**From:** Sarah Fletcher <fletchsa1@gmail.com>  
**Sent:** Friday, August 19, 2016 5:05 PM  
**To:** Scott Greenberg  
**Cc:** Bruce Bassett; Dan Grausz; Council Mailbox  
**Subject:** SEP16-015 and ZTR16-02 - MICA

I wish to appeal the Decision should the City issue a Determination of Non Significance or should the City determine that there are no adverse environmental impacts. I am requesting to be made a party of record, including emails involving the City and receive notice of any public meetings or decisions.

# EXHIBIT A

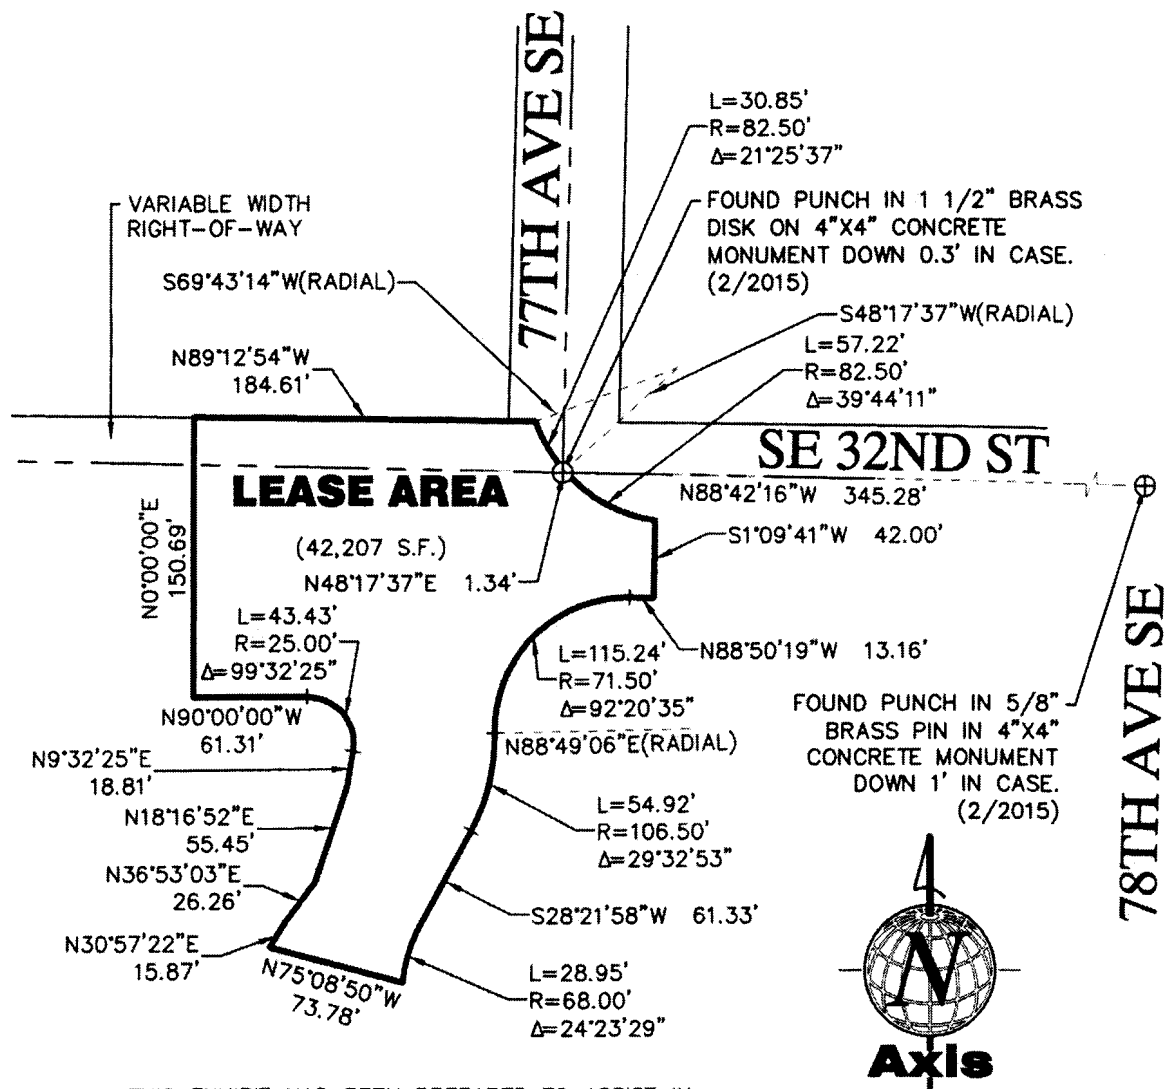
3) Why is the lease site halfway down the street that is next to Mercerdale Park when the proposed building does not come that far down?

What is not clear is that when one looks at the Lease, the border goes halfway down 32nd Street, but if there is supposed to be parking along the whole of 32nd Street, wouldn't the Lease need to be extended to the whole street, rather than just a part? That is why it is not clear as to where the "off-site parking" is? And they are limited in that if the parking is across the road in the Rite Aid parking lot or on the street across the road from the proposed MICA, how does one propose patrons are supposed to get to the parking in a safe manner? Have anyone submitted any parking agreements with private land owners to evidence its "off-site" parking, which should be a requirement for any SEPA review. And if patrons are expected to park in the Rite Aid parking lot, did anyone check with them to see if it is alright to park in their lot, and the same for Farmer's?

SHEET NAME
SITE AND PAVING PLAN

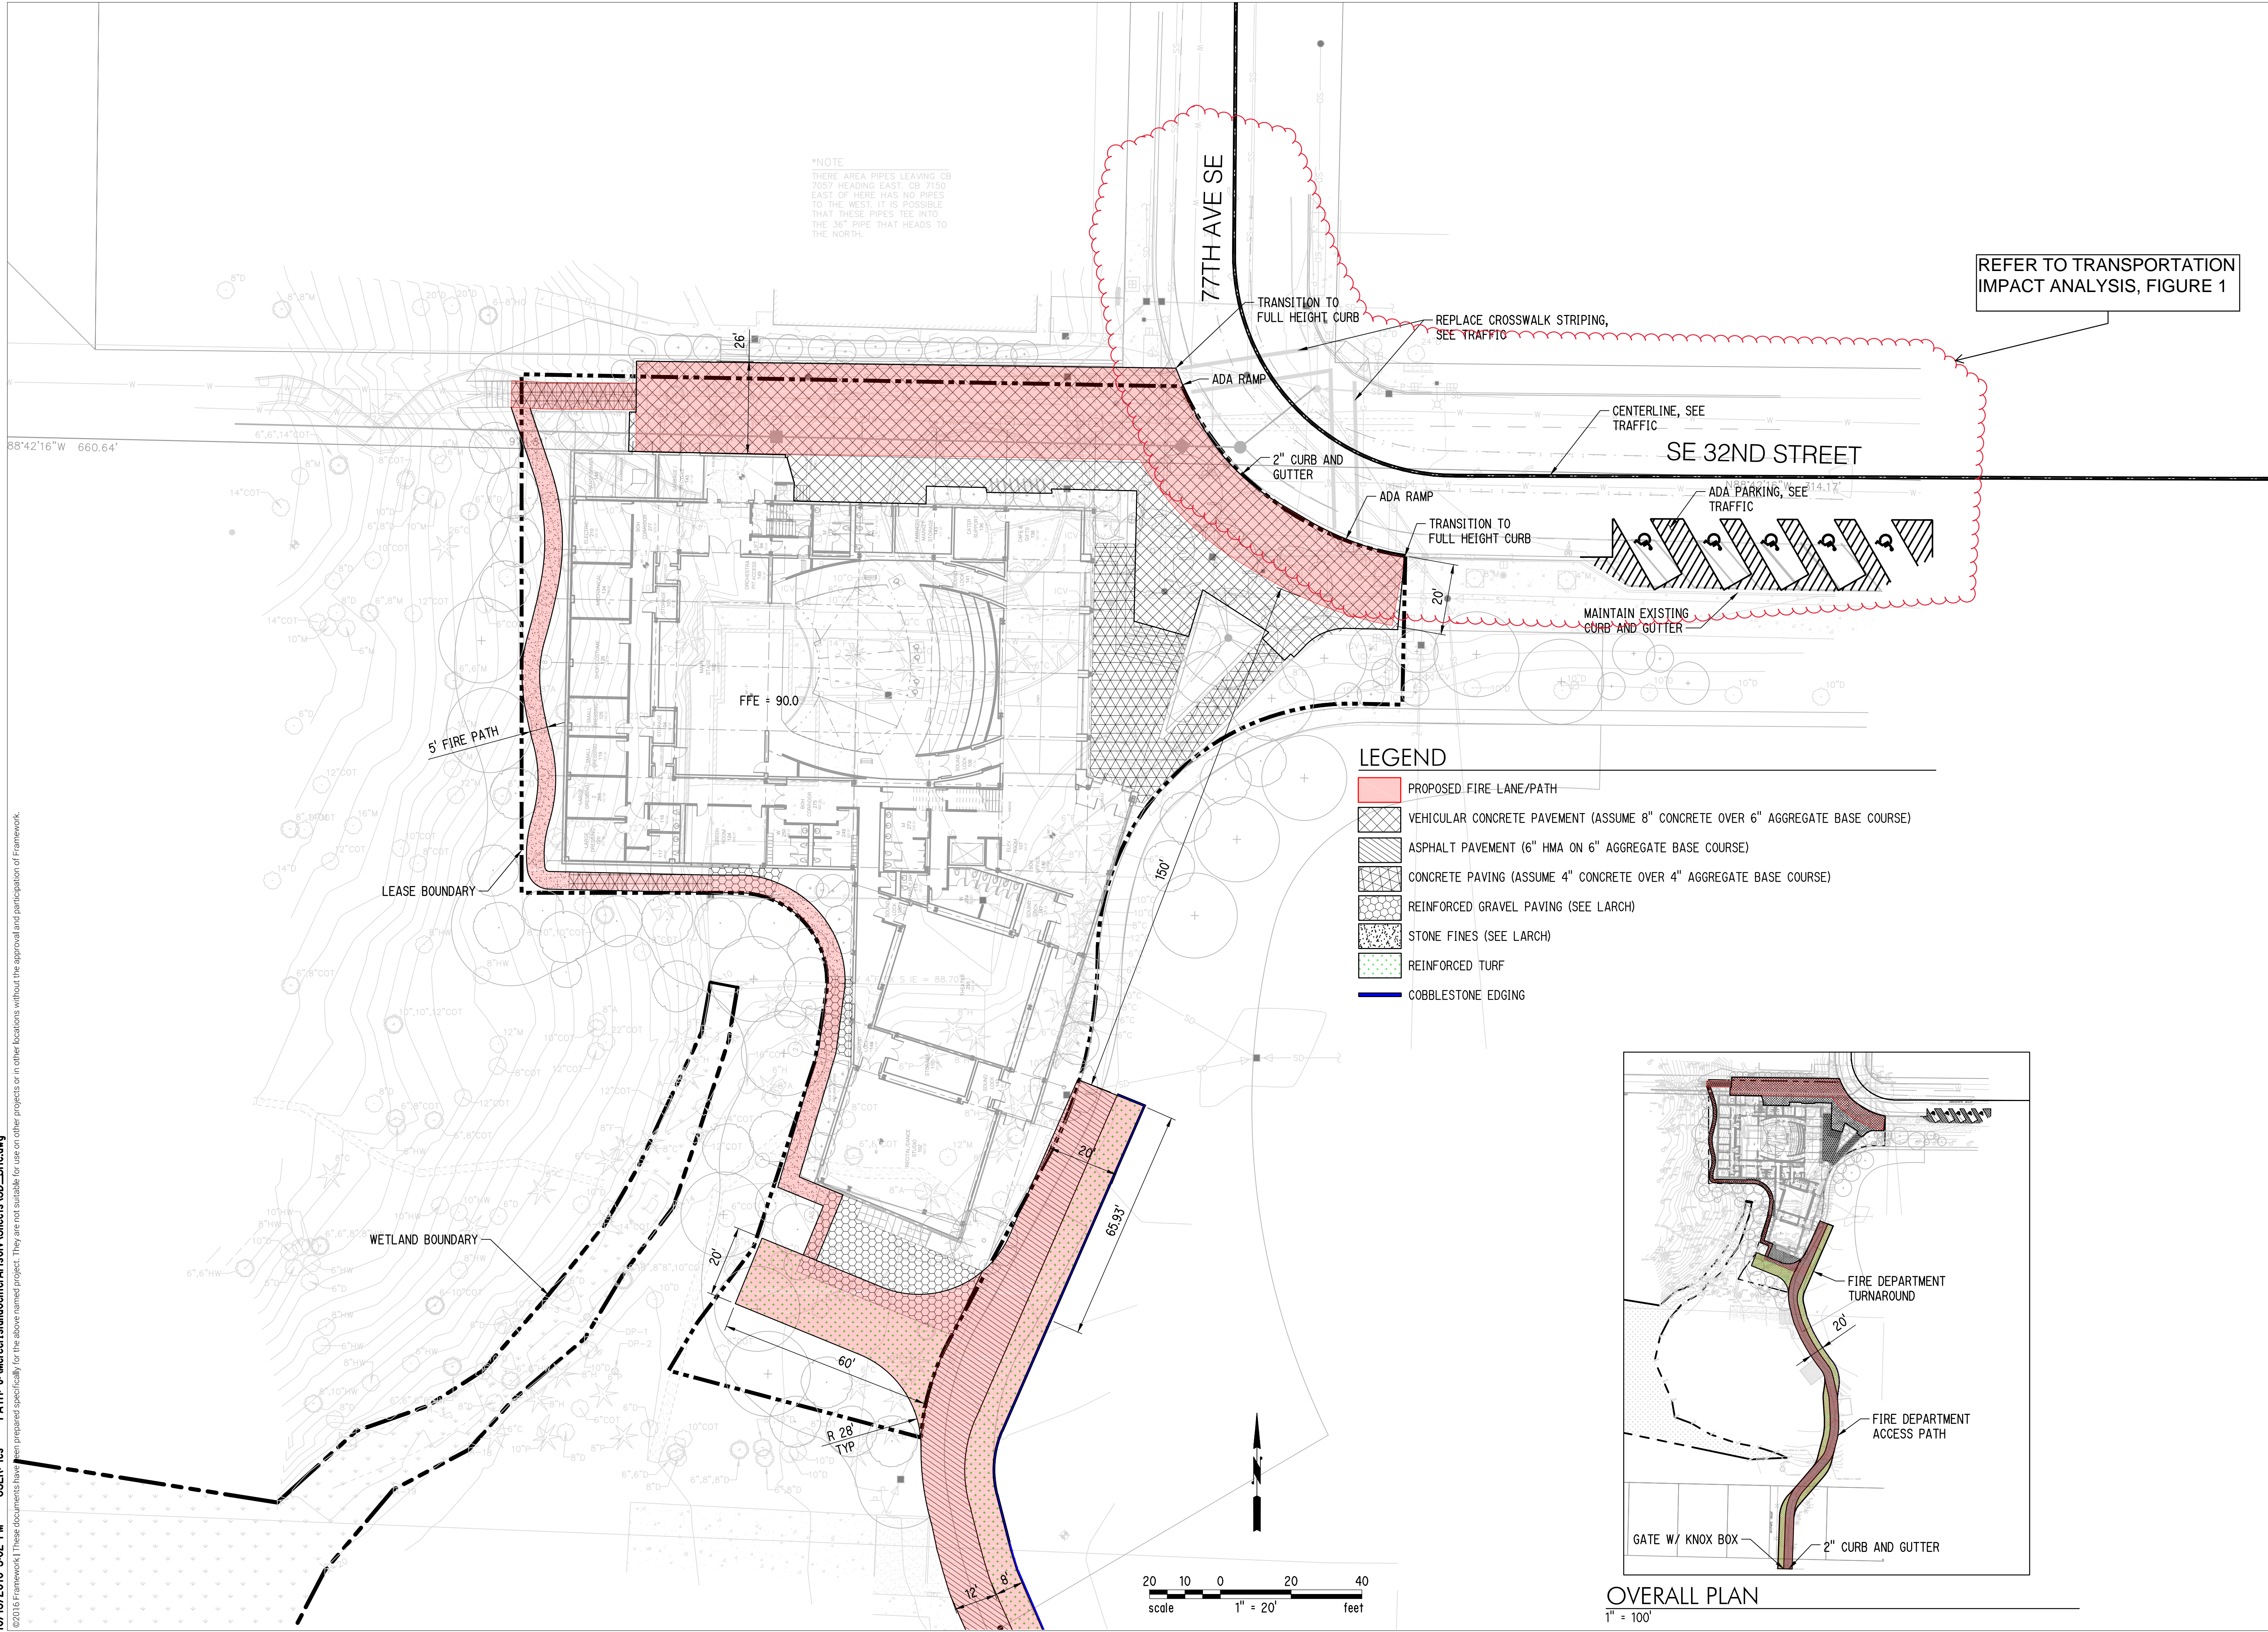
- 1) Will the proposed building encroach onto the path?
- 2) Are they planning on building a new path and if so, where will it go?
- 3) What will happen to the trail, it looks like the path leading down from the stairs above will be blocked by the proposed building?
- 4) What will happen to the Bicentennial Monument in that it is of significance and there is an ordinance on monuments. You can't just demolish it.
- 5) And the public restroom, will the MICA building be open for the public to use the restroom anytime or will it only be open during the hours that MICA will be open?

And the Code talks about "off-street parking," but in the Application, you are talking about "off-site parking," is there a difference between off-site and off-street? Do you think they meant to say "off-street?" To me, "off-site parking" could mean somewhere as far away as the Park and Ride. And are you trying to tell me that people are going to park all the way at the Park and Ride and get a shuttle to MICA and what about the parents dropping their children off, where are they going to be dropping the children off? And how are the refuse trucks supposed to get to the back of the building to pick the trash up from? It doesn't look like you have allowed space for the refuse trucks to get to the back of the building or if there is enough room for them to turn around.

Does MICA comply with the ADA requirement for access for the disabled? The reason I ask is because I have an elderly mum who has a walker and she cannot walk very far. I would have to park outside the main entrance, get her walker out of the back of the car and walk her to the door. Will there be a parking zone for the disabled? And if MICA is to build a long paved driveway to allow disabled persons to be dropped off and picked up with a turnaround, this then increases the impervious surface area which will then add to the building footprint.

MERCER ISLAND CENTER FOR THE ARTS CONCEPTUAL MITIGATION PLAN

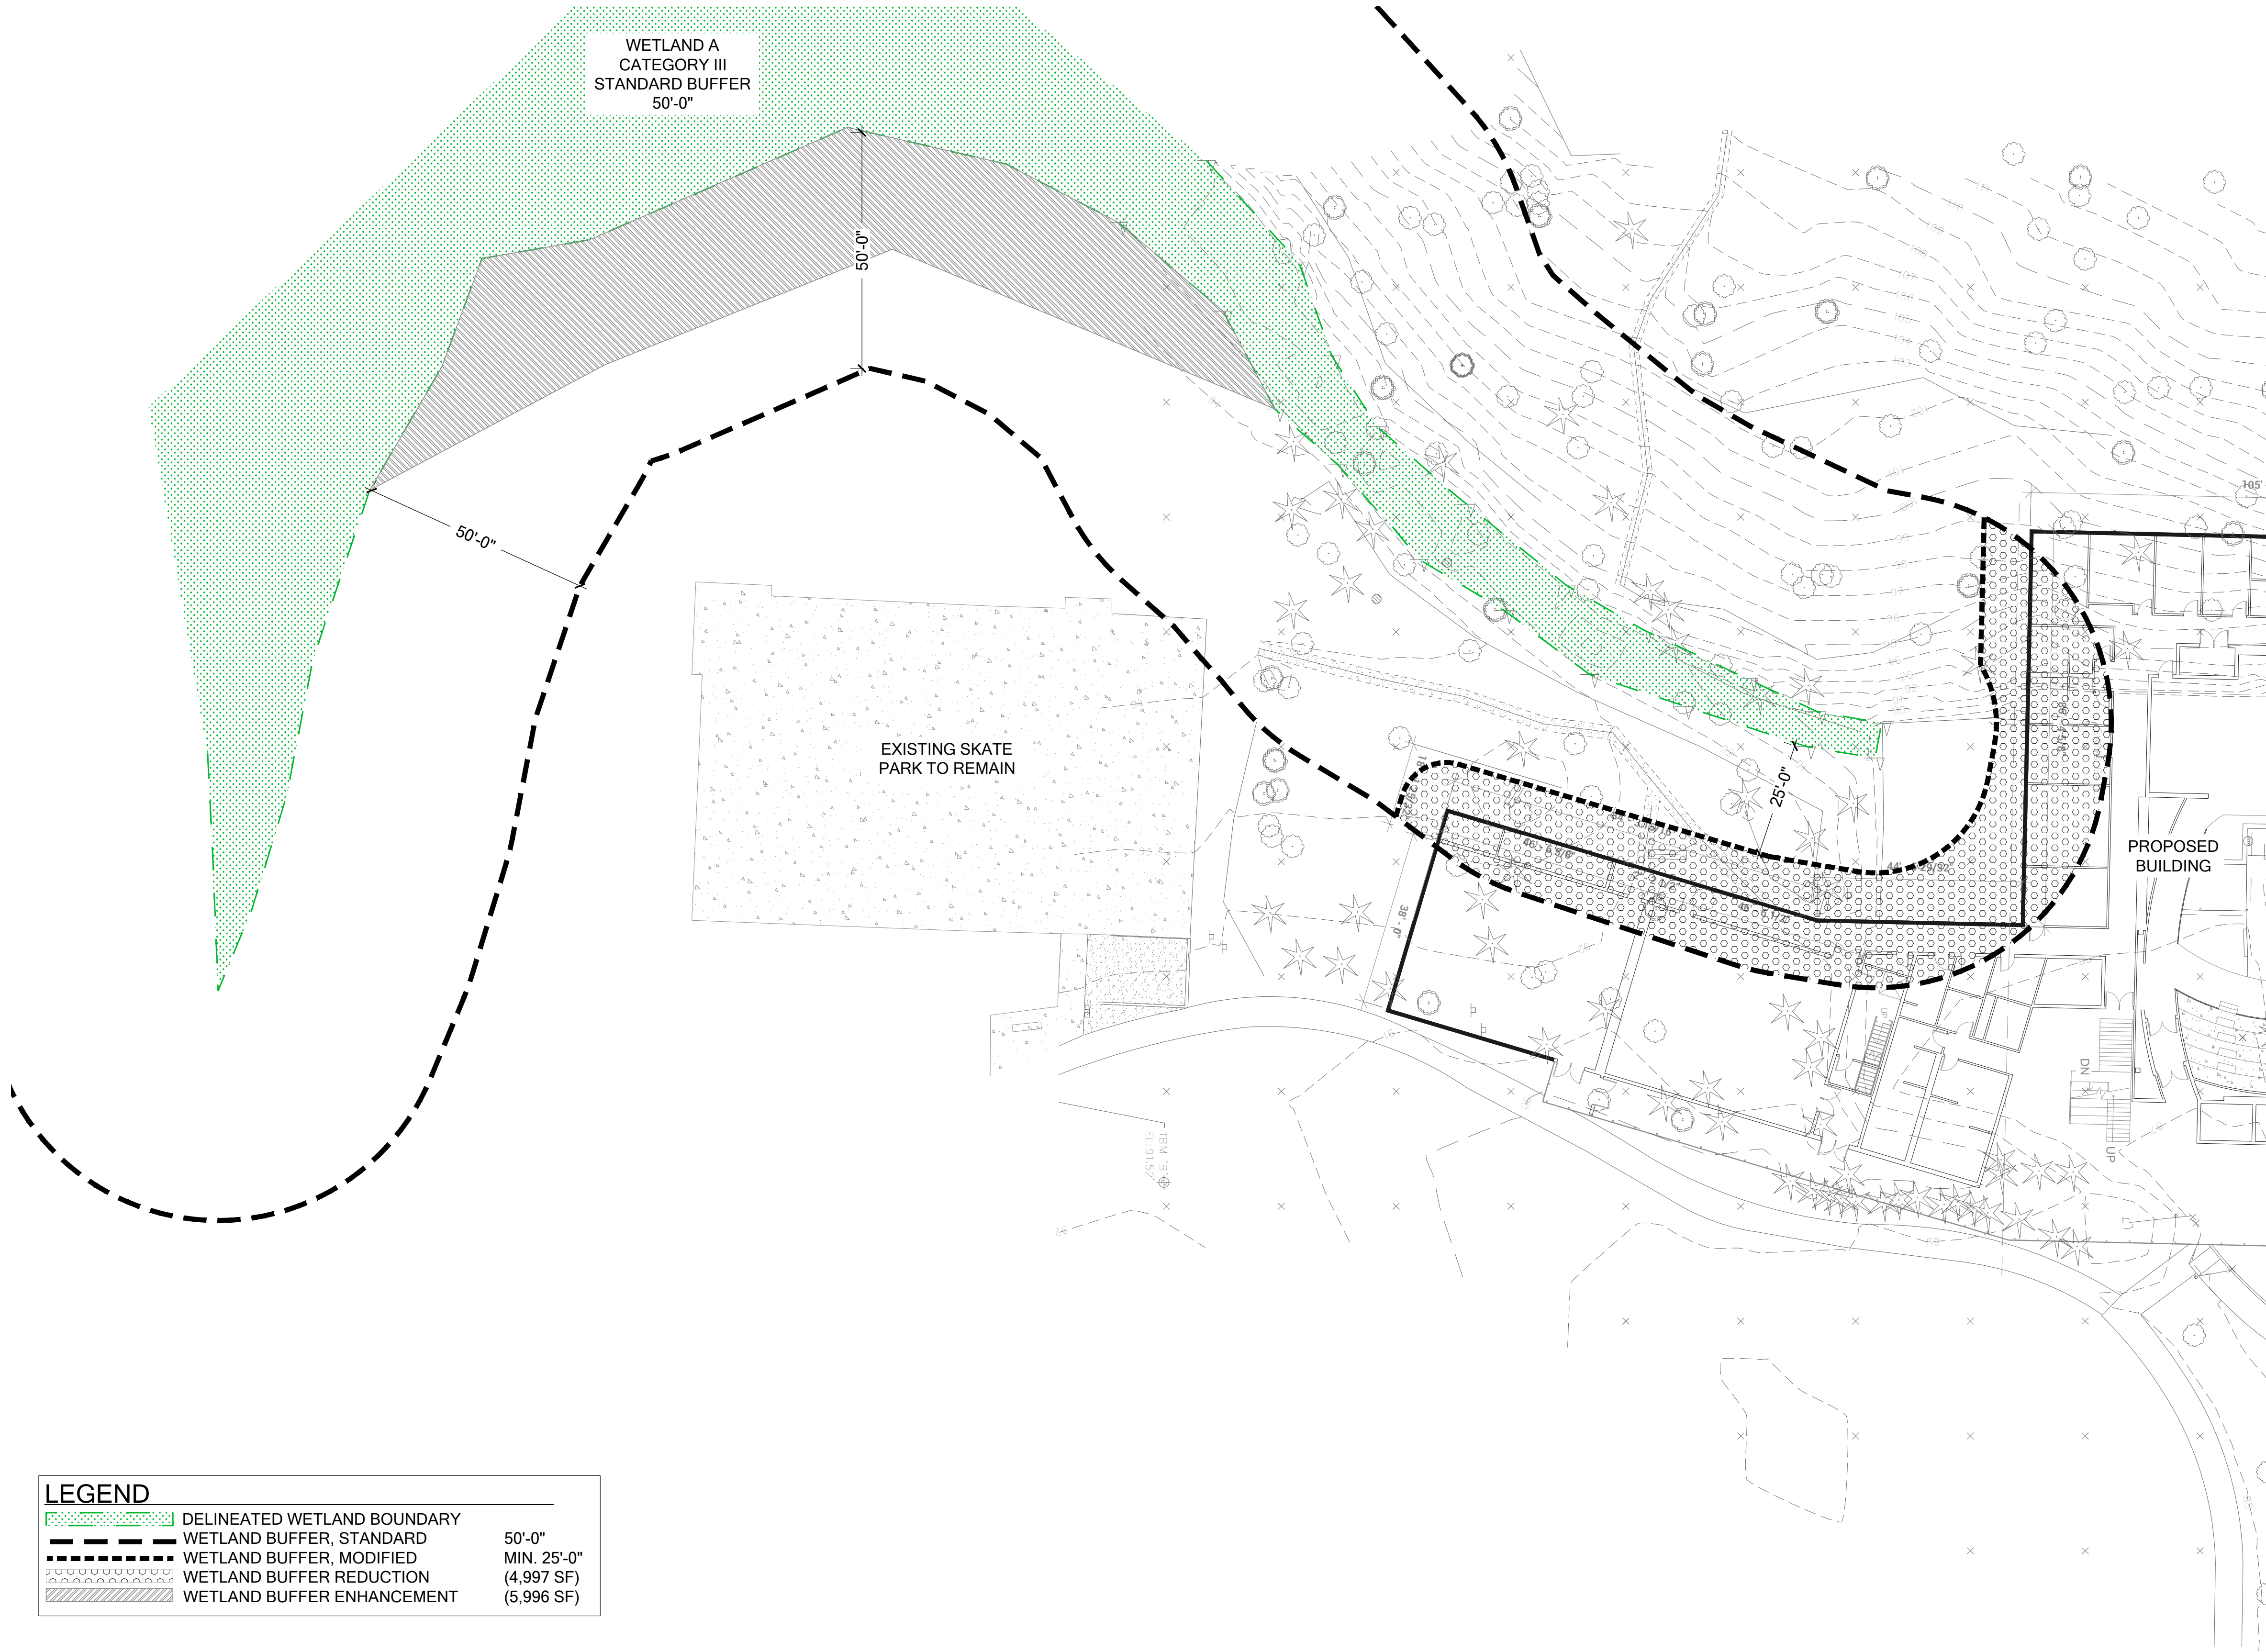
Q: To me, protecting the wetland and buffer and trees and forest area classifies as “natural environment.” Please explain how a large building in the park classifies as protection of the natural environment?

Q: How do you plan on protecting the environmentally sensitive lands, such as where the proposed MICA is to be located?

Although an environmental study was done, it was not done for the hillside behind the proposed building which needs to be done.
